DRB Application No.: 07DRB-70266 (PF) Project # 1006836
Project Name: MCELHENY ADDITION
Agent: SURVEYS SOUTHWEST LTD Phone No: 998-0303

DEVELOPMENT REVIEW BOARD – SPEED MEMO

DRB CASE NO/PROJECT NO: 1006836

**PLAT OF  
LOTS 5-A & 5-B  
McELHENY ADDITION  
PROJECTED SECTION 5, T. 10 N., R. 3 E., N.M.P.M.  
TOWN OF ALBUQUERQUE GRANT  
CITY OF ALBUQUERQUE  
BERNALILLO COUNTY, NEW MEXICO  
SEPTEMBER 2007  
SHEET 2 OF 2**

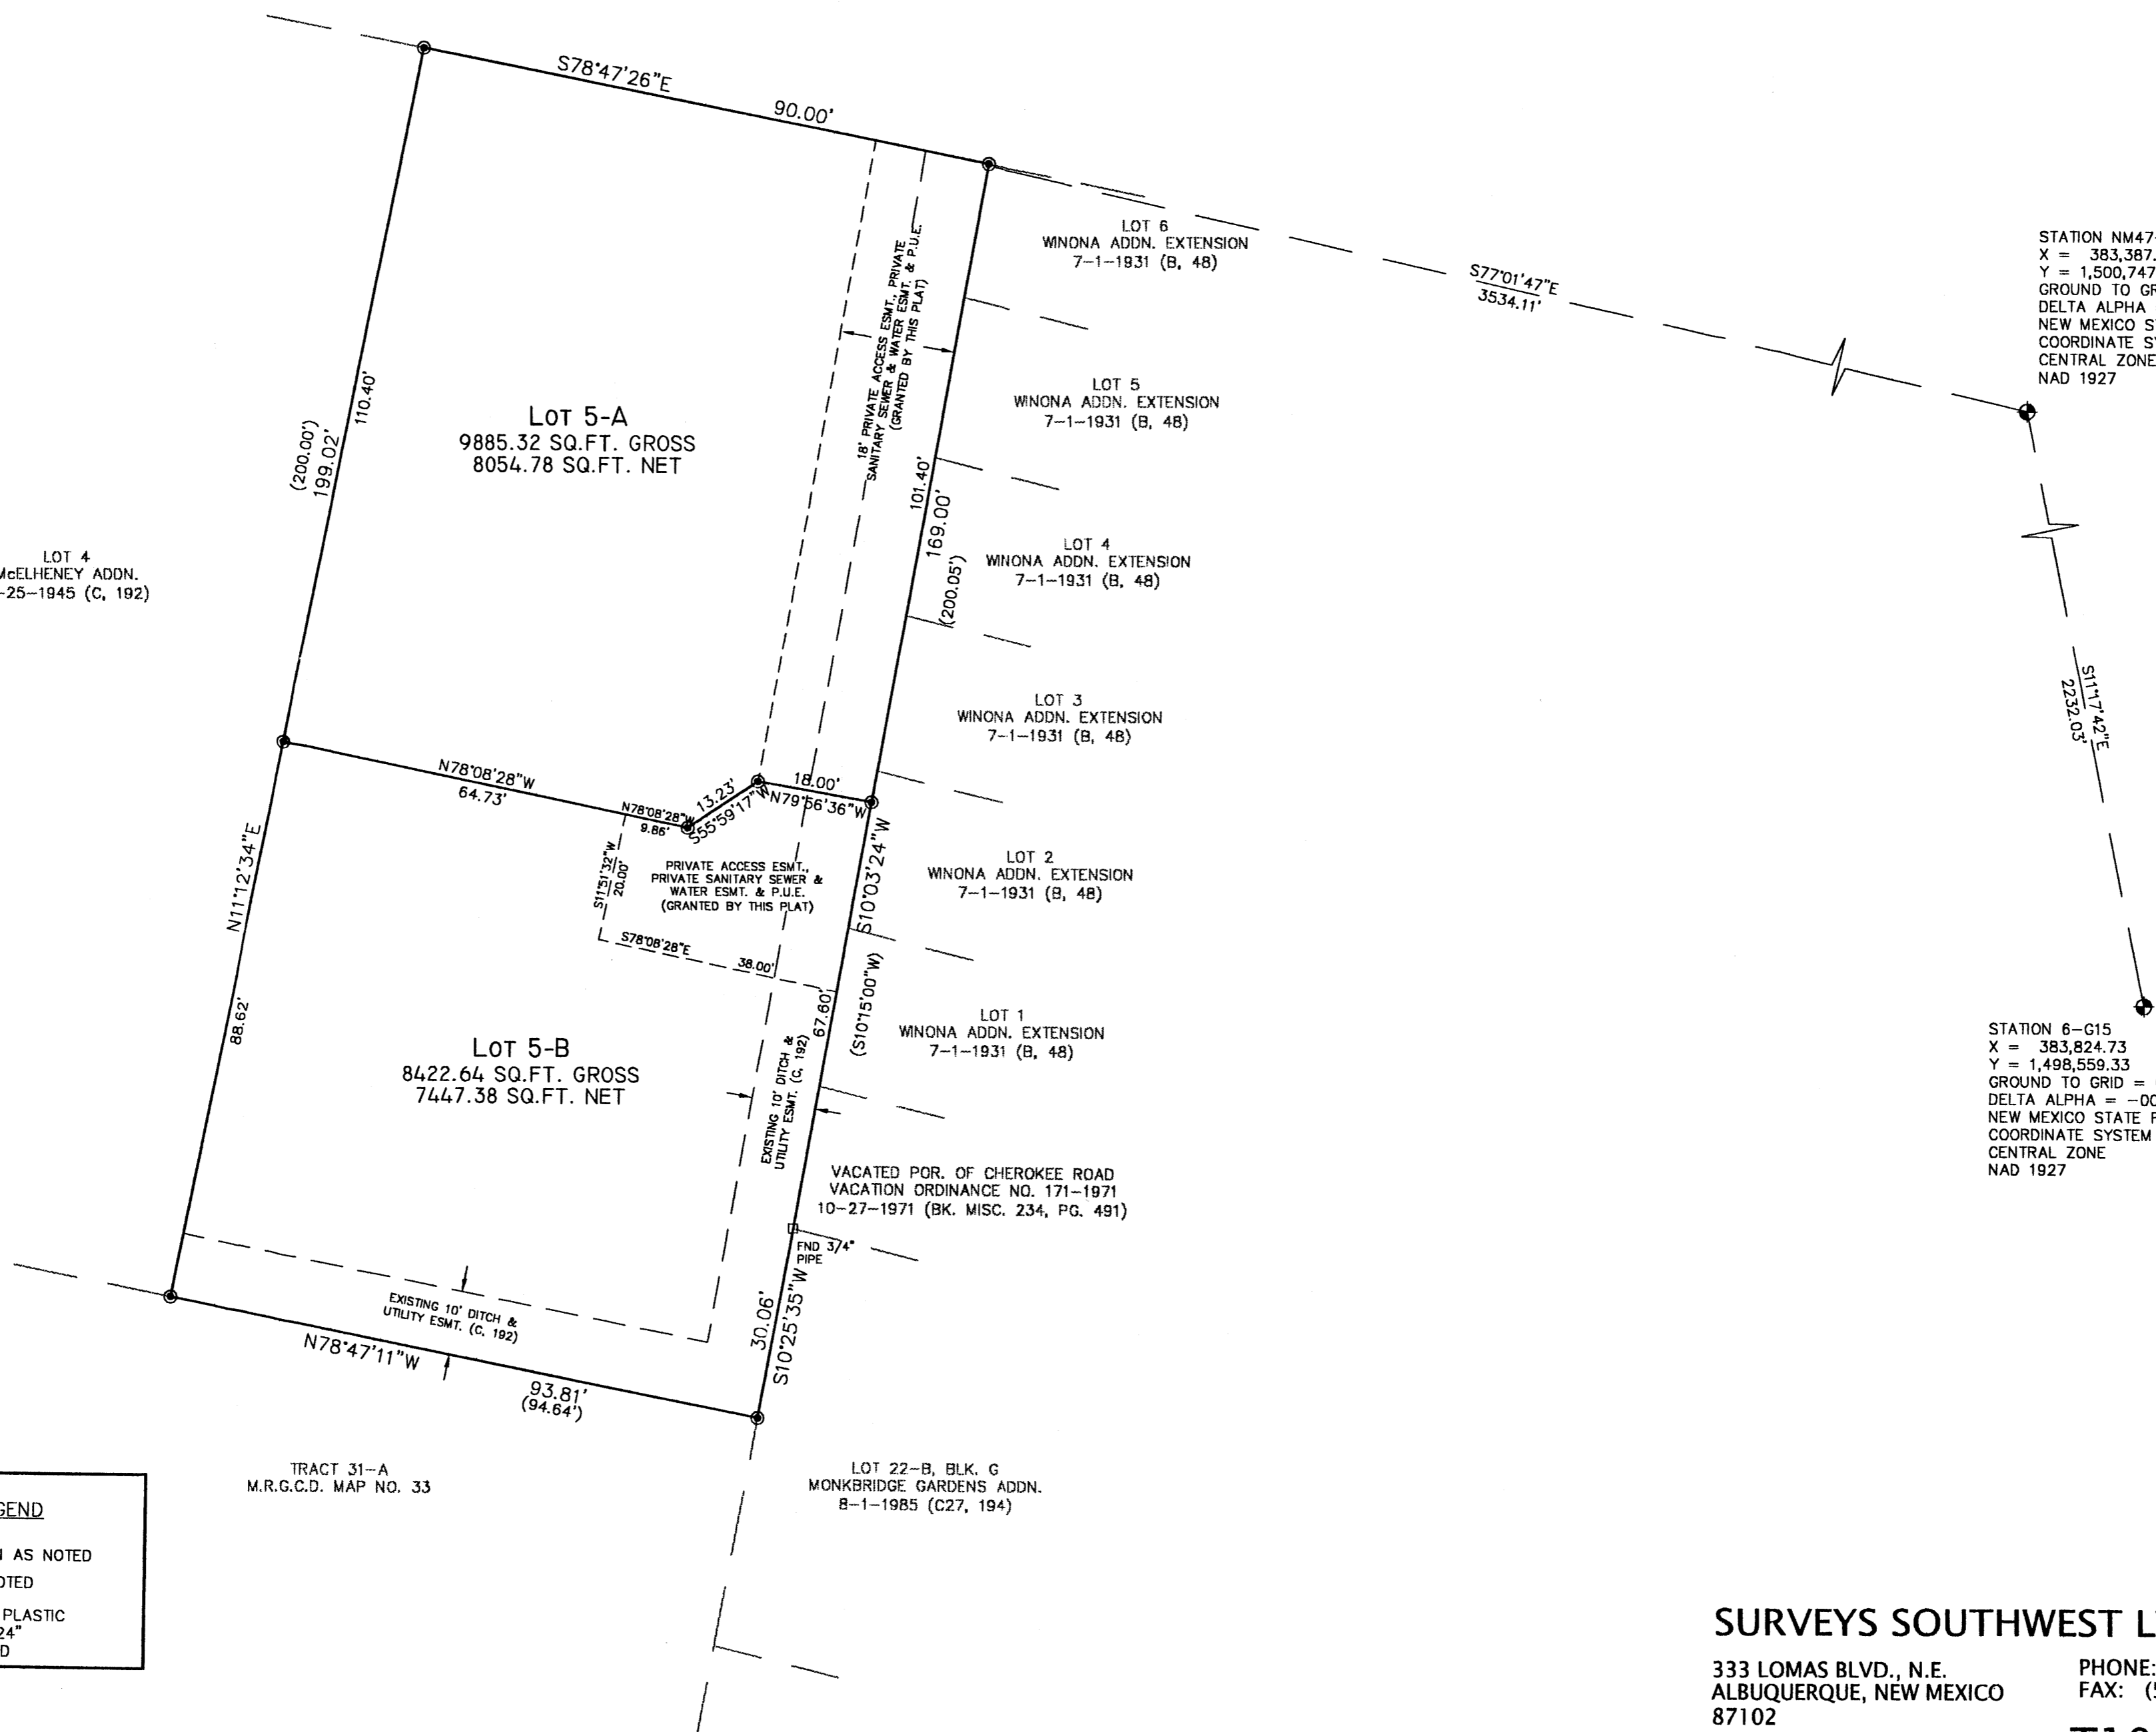
A cross lot drainage easement is required.
